**Response to Submissions
Section 96(1A)
Modification Application
(MOD 2)**

Horsley Drive Business Park

Prepared by McKenzie Group Consulting Planning
on behalf of Australand Property Group
May 2015

Horsley Drive Business Park

DEVELOPED ELEVATION - RETAINING WALL 6
 SCALE 1:250
 UPPER TIER WALL S.A. = 996 sqm
 MIDDLE TIER WALL S.A. = 737 sqm
 LOWER TIER WALL S.A. = 310 sqm

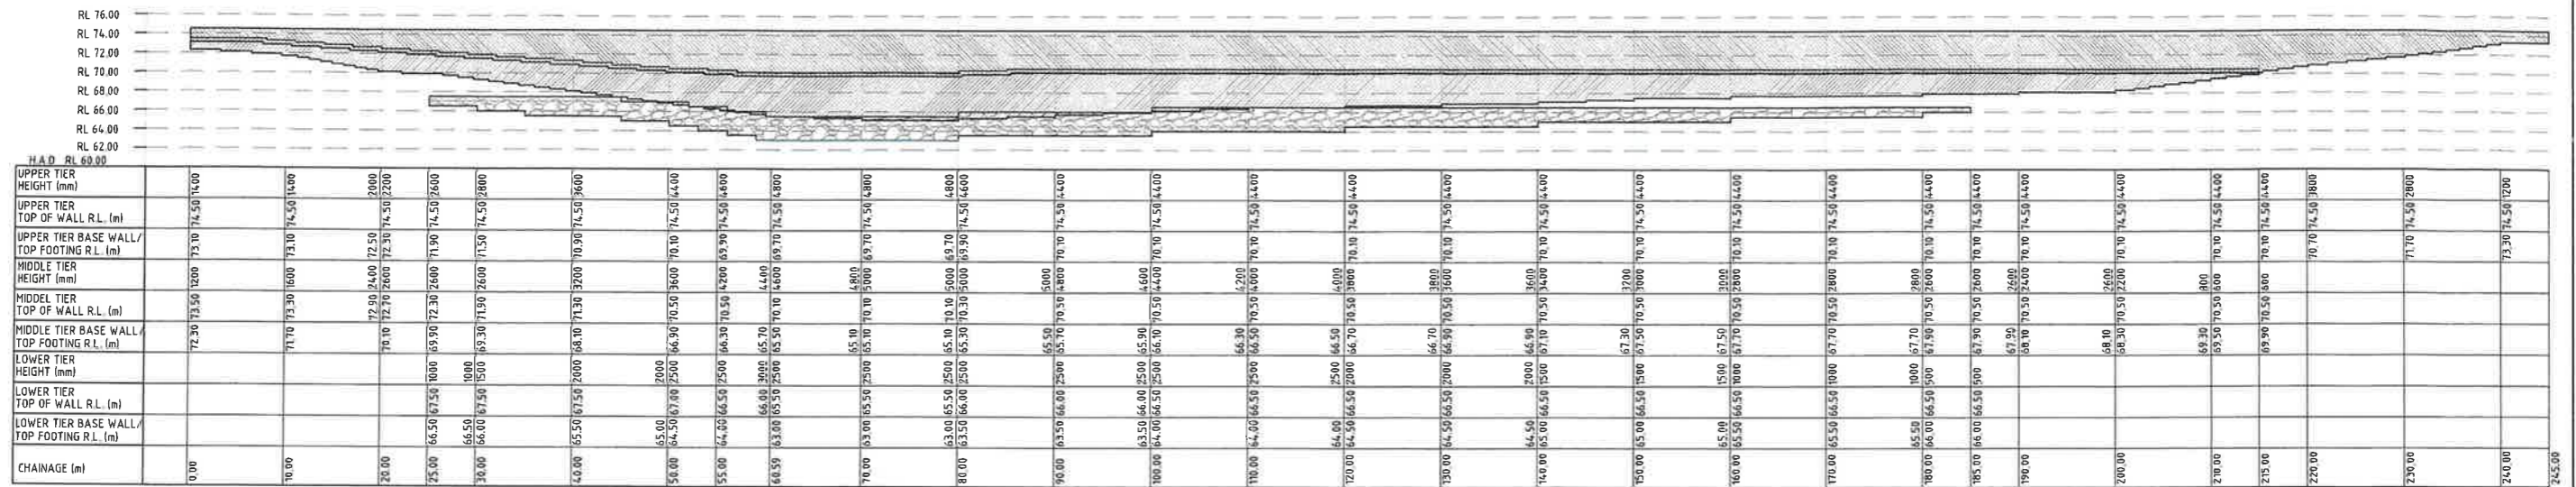
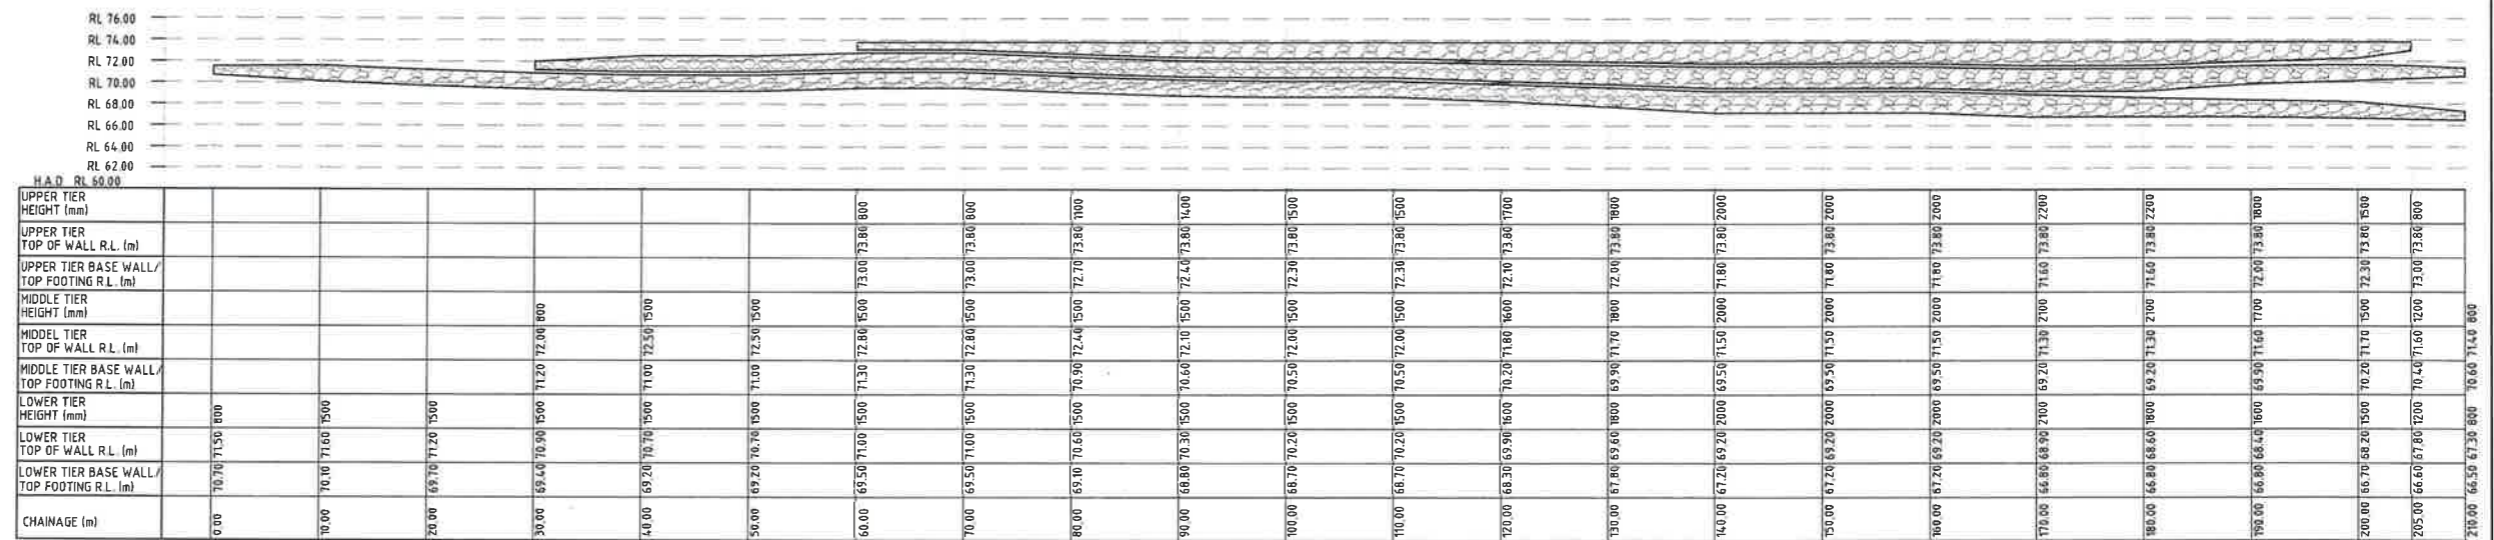
<p>2. <i>The applicant needs to provide additional measures to reduce the bulk and scale of the proposed retaining walls. This includes addressing the needs for additional soft landscaped area, details of the location and depth of planting within retaining walls.</i></p>	<p>As detailed at Appendix 2, the tiered approach of the retaining walls is capable of accommodating planting that will enhance the visual amenity of the site. Suitable depths will be achieved for plants to reach a mature height.</p>
<p>3. <i>The finish of the retaining walls should have a more 'natural' appearance having regard to the setting of the site within the Western Sydney Parklands and gateway position to Wetherill Park.</i></p>	<p>As outlined in Item 1 of Table 1, the proposal seeks to provide:</p> <ul style="list-style-type: none"> ▪ Introduction of boulder walls in lieu of Keystone on the Horsley Drive frontage. ▪ Replacement of the sandstone at the corner of The Horsley Drive and Cowpasture Road with gabions.

Table 2 – Submissions and Responses	
Fairfield City Council	
Summary of Submission	Response
	<ul style="list-style-type: none"> ▪ Undulating curves on the keystone wall on Cowpasture Road. ▪ No stepping up of the formerly sandstone and keystone on Cowpasture Road.

RETAINING WALL COMPARISON PLAN
SCALE 1:500
RETAINING WALLS & BUILDING PADS
AS PER APPROVED DA DRAWING
CO114.92.00-DA62 OVERLAYED IN RED

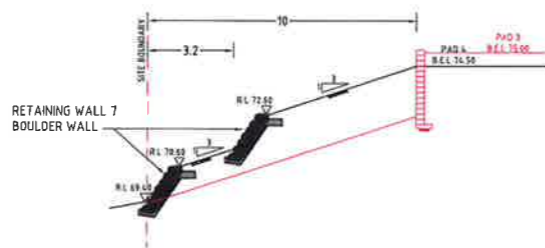
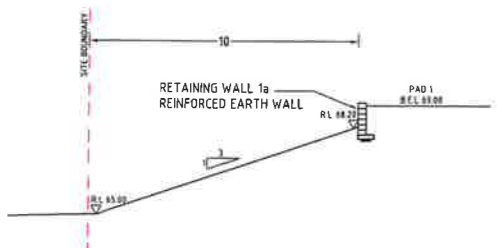
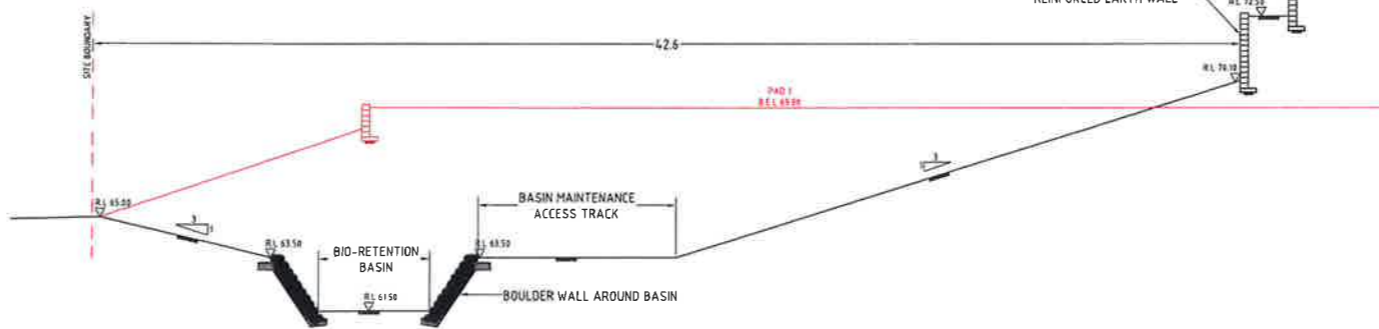
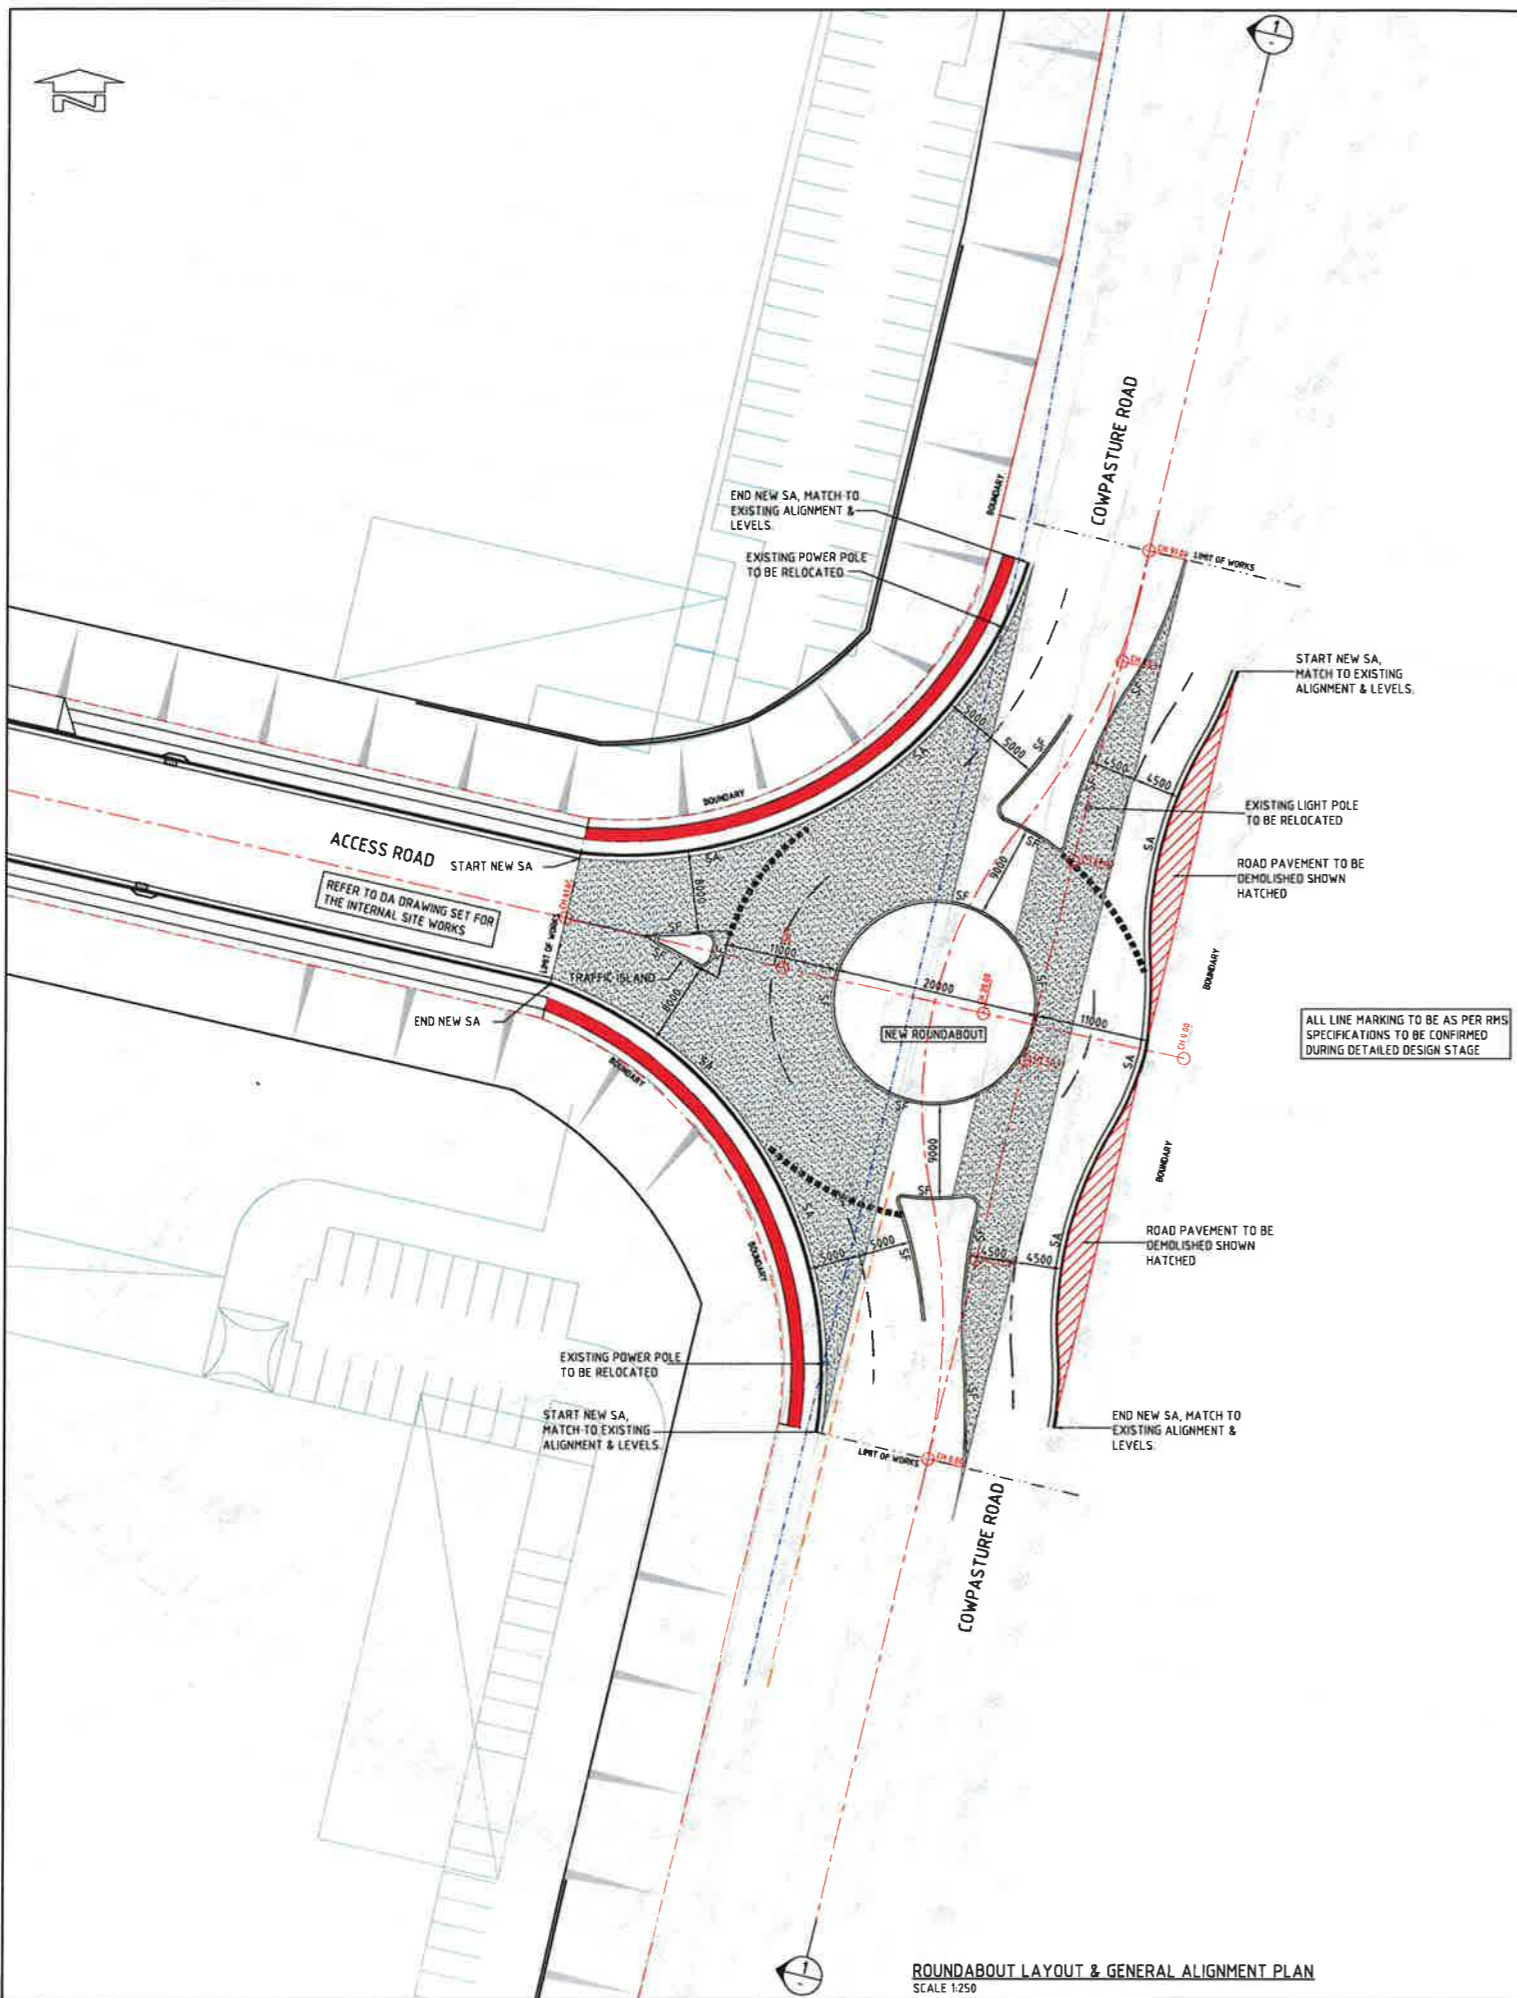
Table 2 – Submissions and Responses	
Fairfield City Council	
Summary of Submission	Response
<p>1. <i>The applicant needs to provide further justification as to why the modified retaining walls along Cowpasture Road should be constructed to the proposed height, approximately 4.5 metres above the approved height under the approved application.</i></p> <p><i>This should also include justification for the amount of fill now proposed at the south eastern corner of the site. Council officers note that there would appear to be capacity to provide greater balance in the amount of fill along the eastern boundary of the site such that building pads and the height of retaining walls could be lowered in the south-eastern corner without compromising other site development and infrastructure (i.e. access and site drainage) issues.</i></p> <p><i>In particular, it is unclear to Council officers as to why the pads on the southern side of the proposed access road are significantly higher than the pads associated with Stage 1 of the proposal on the northern side of the access road, leading to excessive height in the pads along Cowpasture Road resulting in unsatisfactory urban design outcomes in the development.</i></p>	<p>As noted in item 1 of Table 1, the proposal now seeks to introduce new materials and treatments that are capable of accommodating planting and providing a stepped approach to the retaining of the Horsley Drive/Cowpasture Road frontage.</p> <p>Despite the increase in height in the order of 4.5 metres, it is considered that the modified design will sufficiently offset any visual impacts by stepping the retaining walls, increasing provision for planting and using materials enhance the presentation to the frontages (refer Appendix 2).</p> <p>In relation to the pad level height difference between the southern and northern side of the site, this has been proposed as the earthworks are going to be carried out in a staged manner with no material exported from the site. This will allow for the development of the estate</p>

4. <i>The applicant needs to provide more detailed information including fully dimensioned plans and levels regarding the above.</i>	Fully dimensioned plans are provided at Appendix 2 and clearly illustrate the net improvement of the proposal.
